Re: BusConnects Lucan to City Centre Core Bus Corridor Scheme
Lucan to Dublin City Centre

Lucan to City Centre Core Bus Corridor Scheme – Bus Connects

I make these comments as a resident of Palmerstown Avenue following a thorough review of the proposed Bus Connects corridor. There are several significant issues with the proposed development. I ask the Bord to consider the lived reality of all current and future residents who live within the Palmerstown boundaries.

| Drawing File Name: BCIDA-ACM-GEO_GA-0006_XX_00-DR-CR-0017 | Sheet Number: 17 of 31 | Status: A | Rev: M01 |

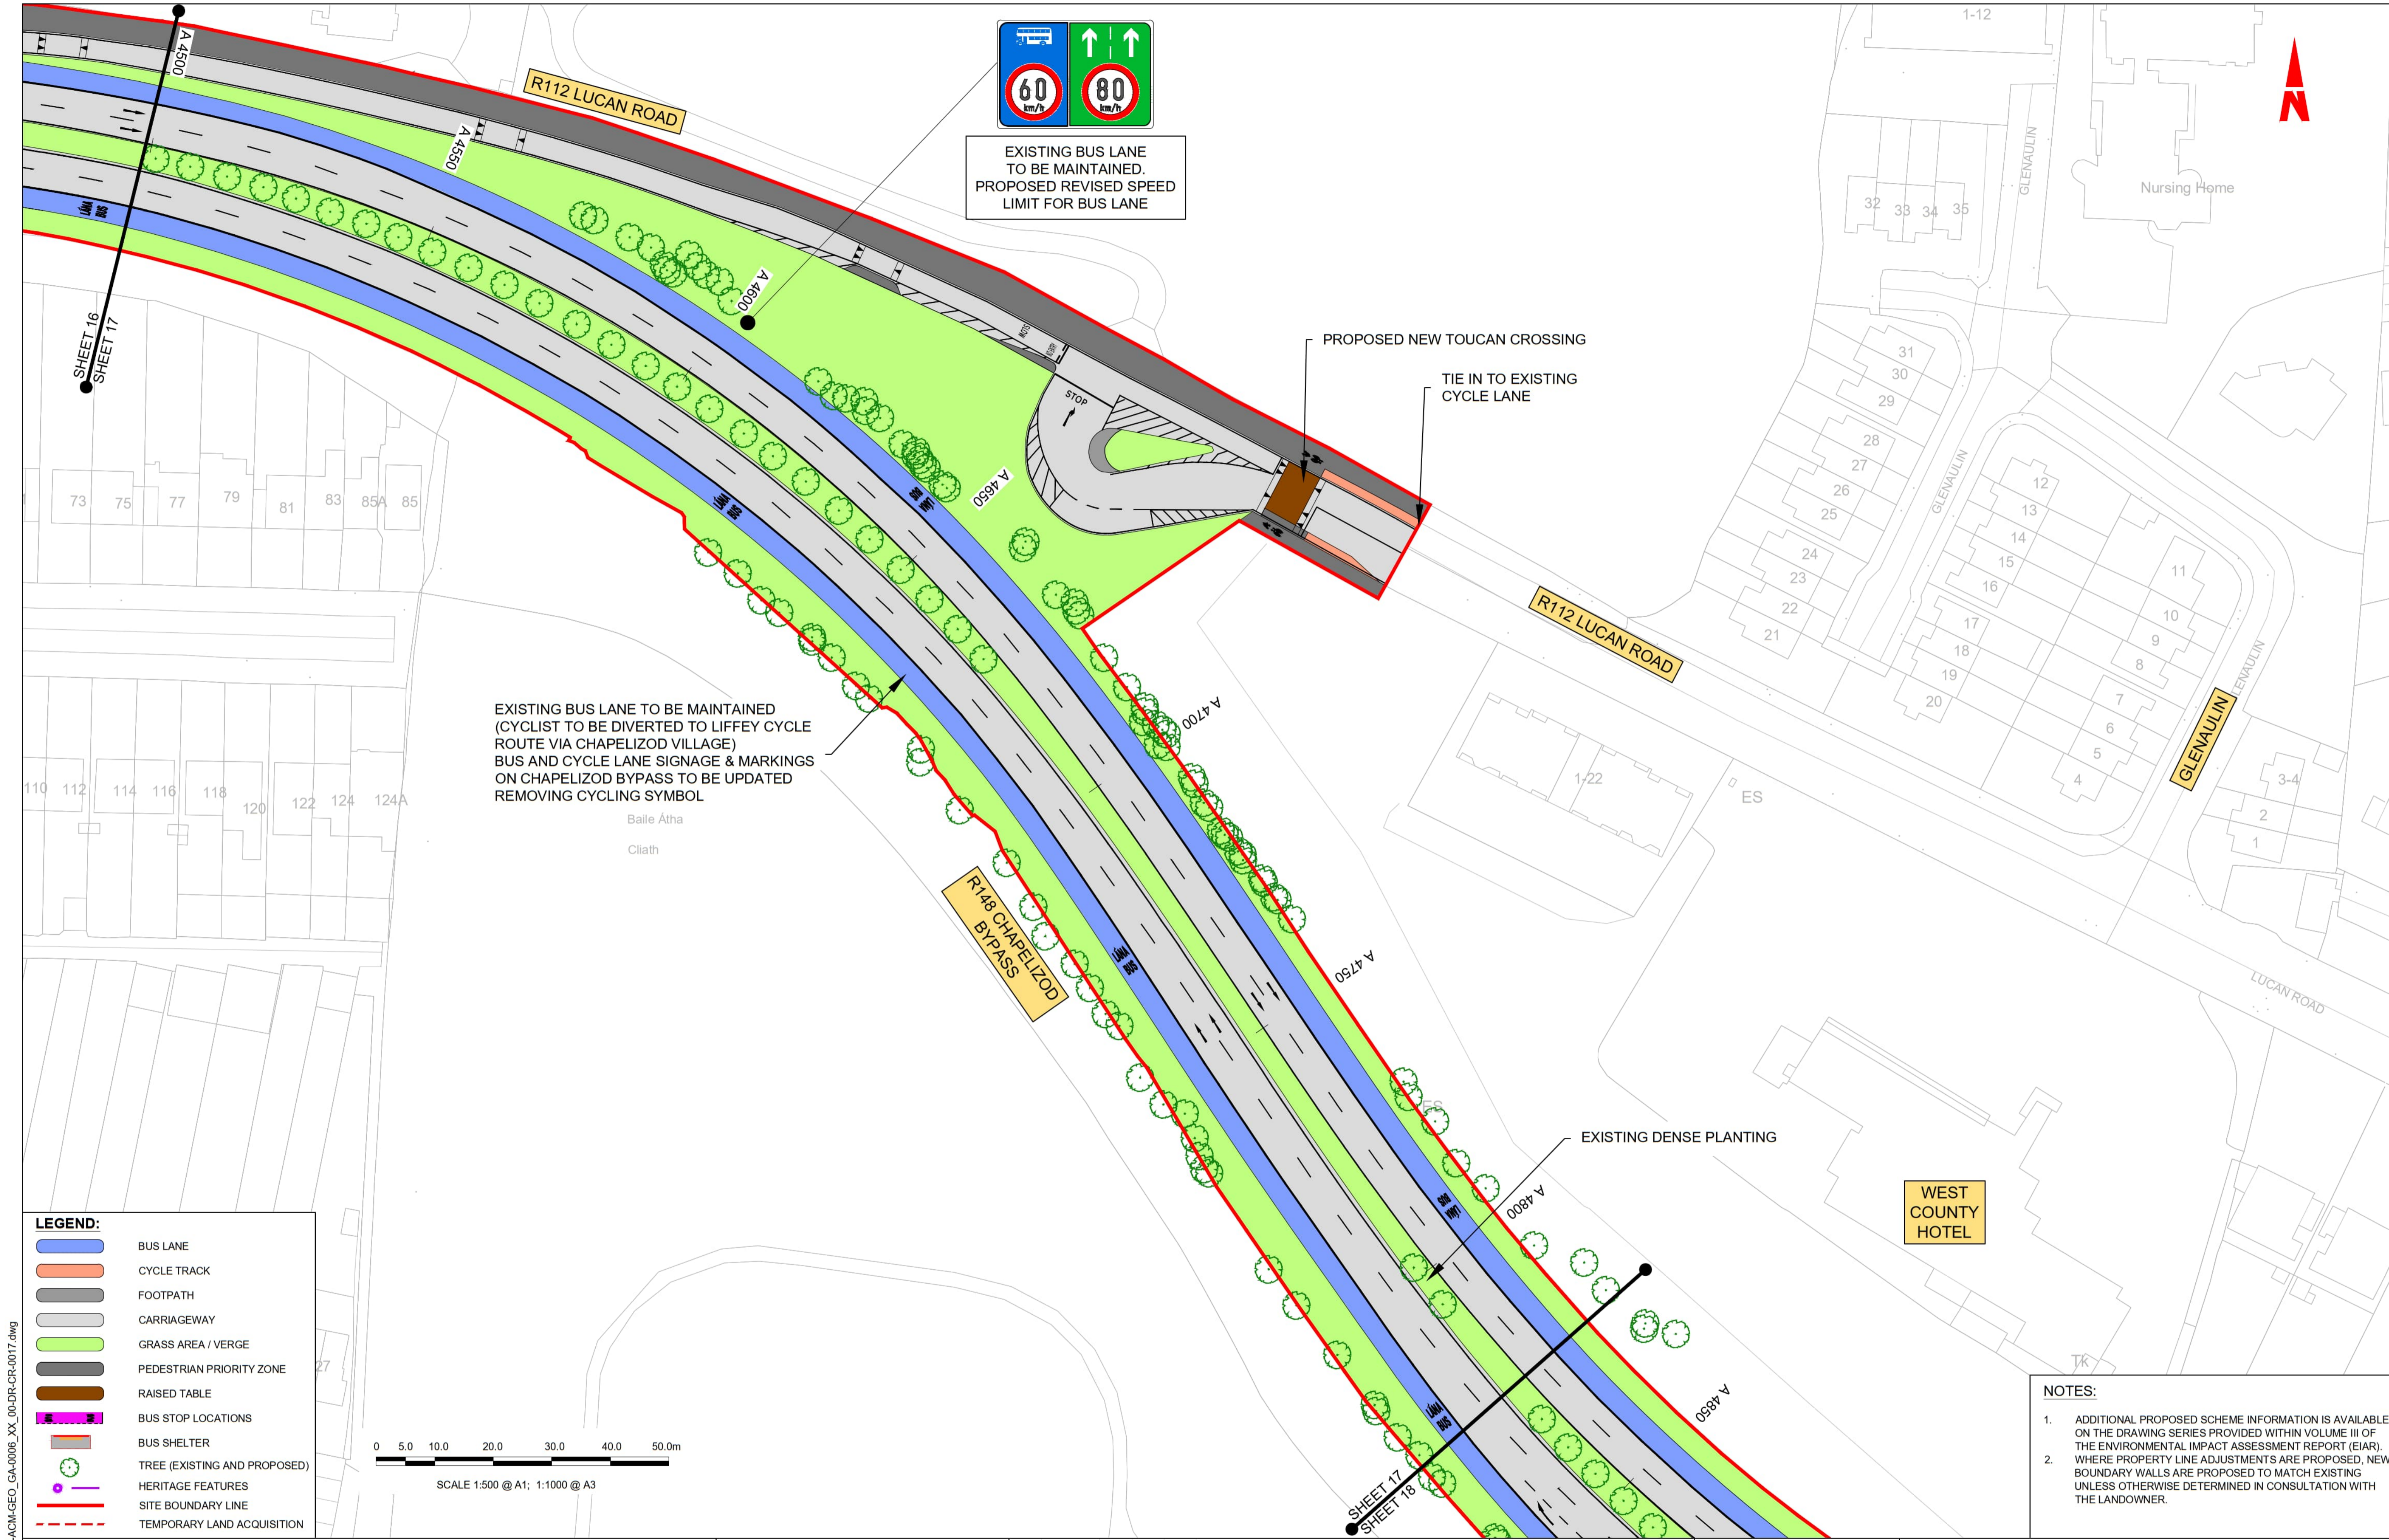
Changes Proposed at the Oval junction

1. Removal of left filter entering the Oval from R148.

The road will be four lanes wide at this point. Two main lanes and a bus lane on the left and right to enter the village. The removal of left filter will mean residents sit in the main traffic lane waiting for the busses to move before turning left. This delays westbound traffic and is unnecessary. Cyclists will continue to use this lane as it is the most direct route westbound, **forcing cars to turn left across the bus lane will likely result in danger for cyclists** (See screenshot below). The existing situation of a short-left filter does not impede bus movement, allows cyclists to take a safe position on the right-hand side of left turning vehicles and should be maintained.

road to one lane here will have a negligible improvement to bus movements as traffic is nearly always clear after the Kennelsford road junction, hence buses aren't delayed at this point. (Heading eastbound, out of town).

The Inspector should include a condition that NTA progress the County objective of a grade separated junction and that the existing road layout between Kennelsford road and M50 be maintained as it works and does not need to be changed for the worse.

Taken from Lucan Scheme General Arrangement Drawings (Page 17) -> [Link](#)
